Further assessment of trees adjacent to the A3 boundary

RHS Wisley, Surrey

J2002 - M25 J10 DCO further tree assessment

2nd July 2020

Drawing Number: **HE551522** | Originator: **ATK** | Volume: **ELS**

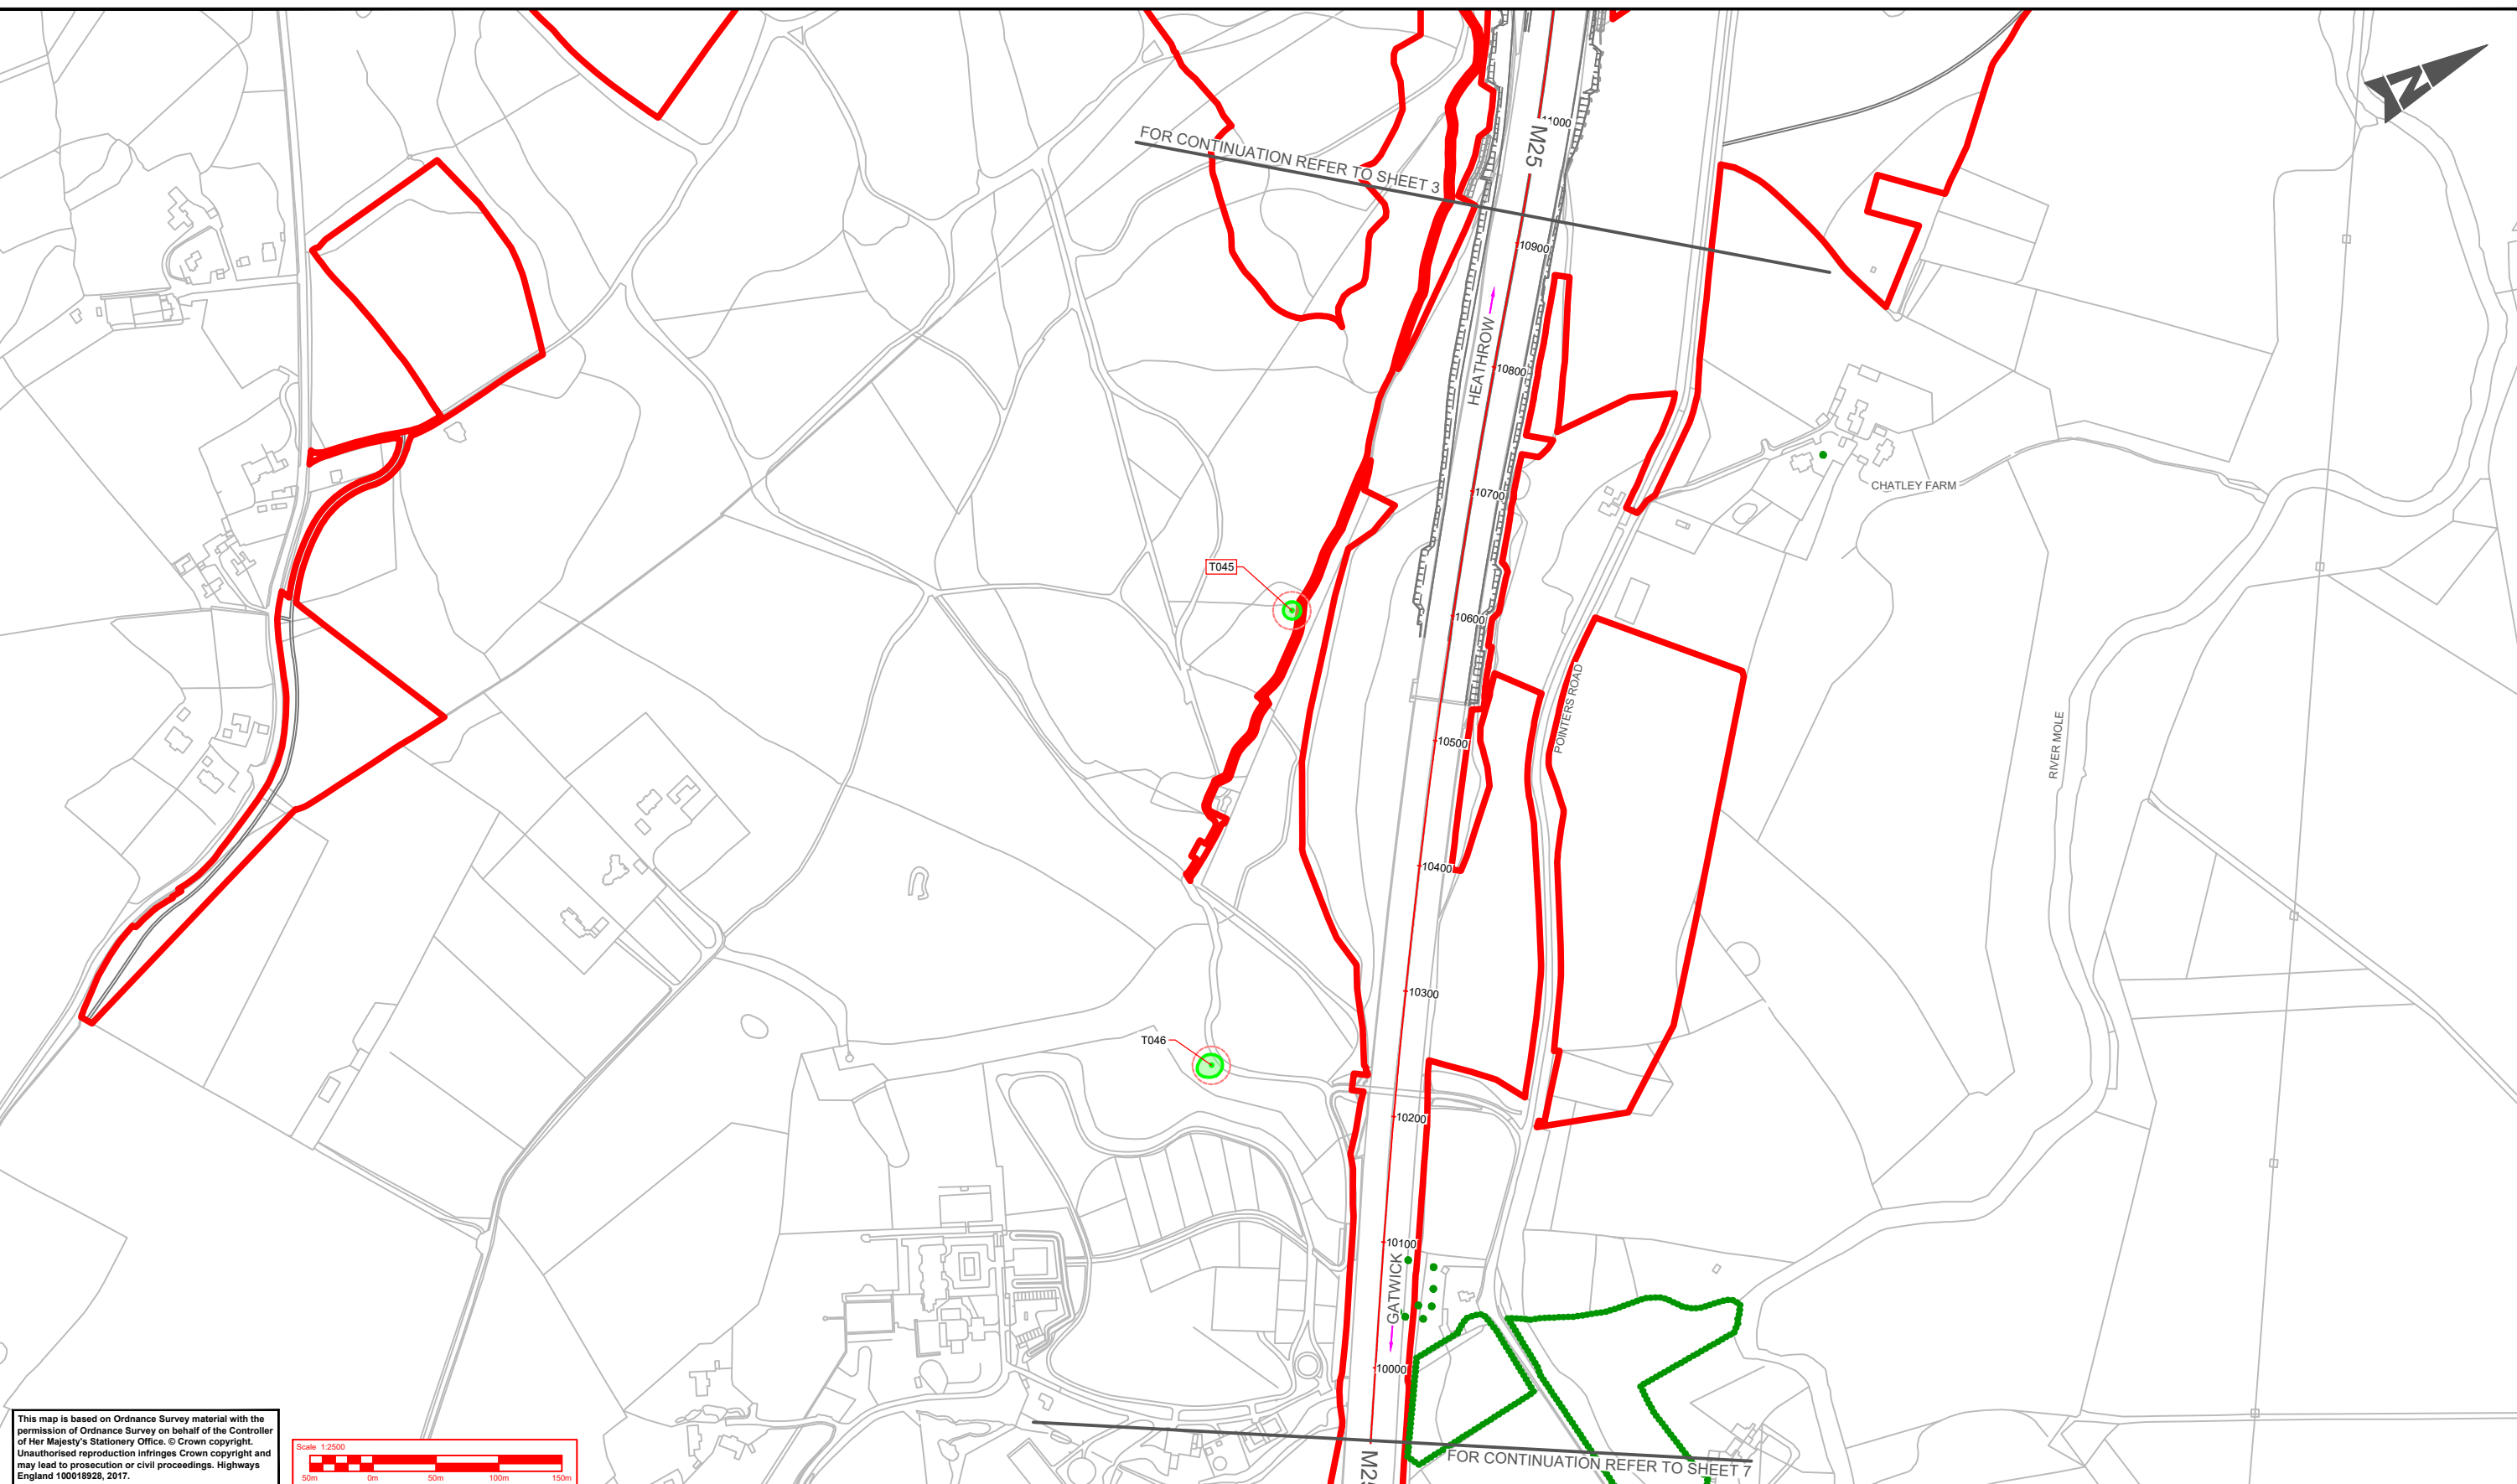
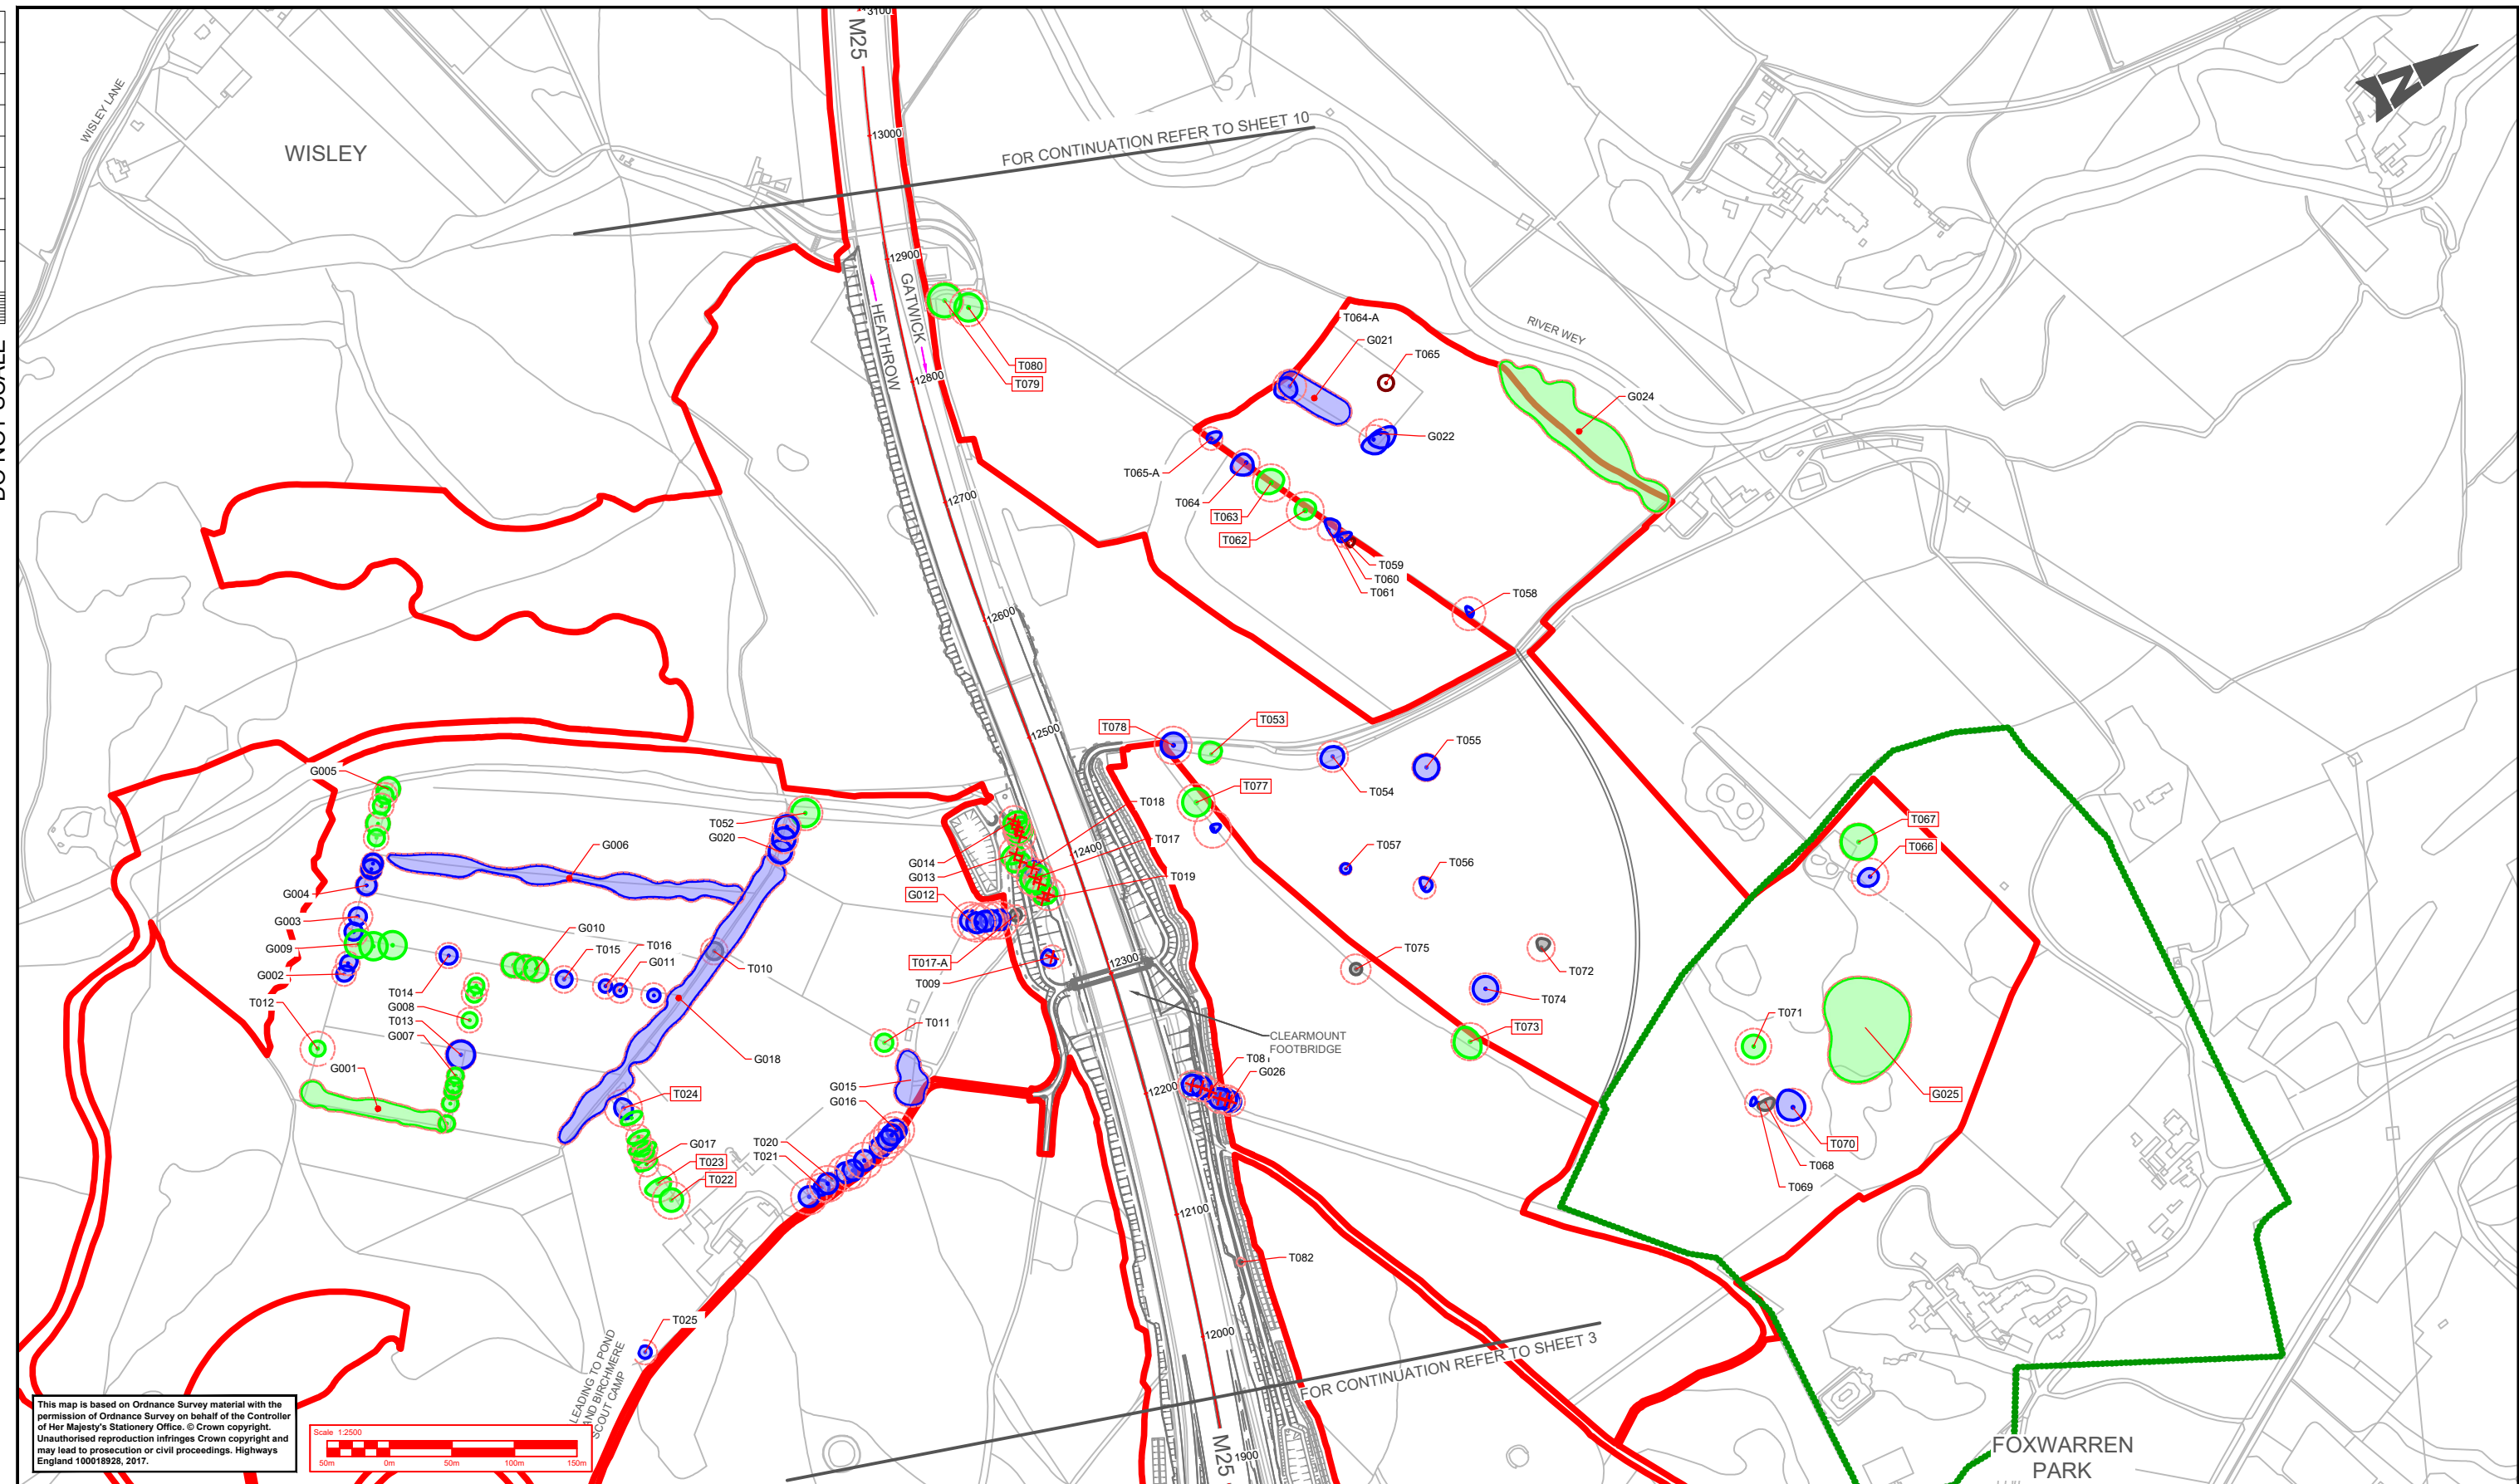
From my review of the HE survey and comparing it to the 44 trees that I identified as being at risk, I found that the HE survey failed to:

1. take any account of the heritage or financial value of any of the Wisley trees that could be adversely affected;
2. to follow the guidance in BS 5837 on respecting RPAs;
3. to identify 16 trees (1, 2, 4–17) as impacted through the Wisley Lane changes; and,
4. possibly account for a further 15 trees (18–22, 24, 29, 31–33, 35, 37, 40–42) that could be adversely affected and may also have been missed from the HE survey.

I concluded that my plan BT1 in Appendix 1 is a reliable record of trees that could be affected, whereas the HE survey is demonstrably not.

From my assessment in my report of 17th April 2020 (Let1-170420-JB), HE has not taken any account of the heritage or financial value of any of the Wisley trees that could be adversely affected. Furthermore, that assessment failed to follow the guidance in BS 5837 on respecting RPAs, and it certainly failed to identify 16 trees (1, 2, 4–17) as impacted through the Wisley Lane changes. Additionally, because of lack of clarity in the HE data allowing a positive identification, there is also possibly up to a further 15 trees (18–22, 24, 29, 31–33, 35, 37, 40–42) that could be adversely affected and may also have been missed from the HE survey.

In summary, plan BT1 in Appendix 1 is a reliable record of trees that could be affected, whereas the HE survey is demonstrably not.
